**BUTLERS, FORE STREET, OLD HATFIELD, AL9 5AN**

**Planning Reference S6/2010/1711/FP (11 August 2010)**

**Re: Formation of replacement car park for business use including layout of additional parking for residential occupiers, paths, landscaping and ancillary works at land adjacent The Viaduct Hatfield Park Church Lane HATFIELD**

DRAWING NUMBER:
045-VC-002 B

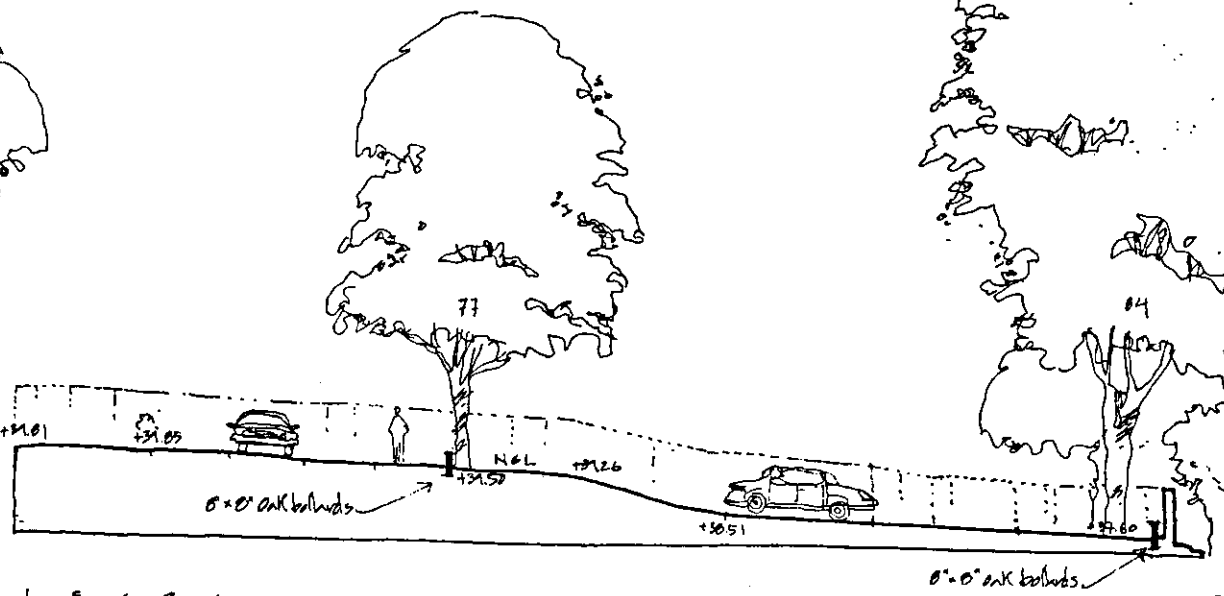
3. Planning proposal 2, para 4.12, and fig 6. Page 15 (new car park, paths etc approximately behind Hill House up to Park Cottages and the maisonette block in Park Close) – please clarify that the 'path' is not in effect a newly constructed road, and where does the gate or doors indicated lead?

4. As you are aware there is a very valuable parcel of land, known as 'The Orchard' situated behind 16 Fore Street (owned by the Estate). Planning applications previously submitted were unsuccessful on the grounds of 'Access', but if 'the path' indicated in Fig 6. Is in fact a road, linking up to the residential 'Whitstone House', it would provide the essential and perfect access into this site.
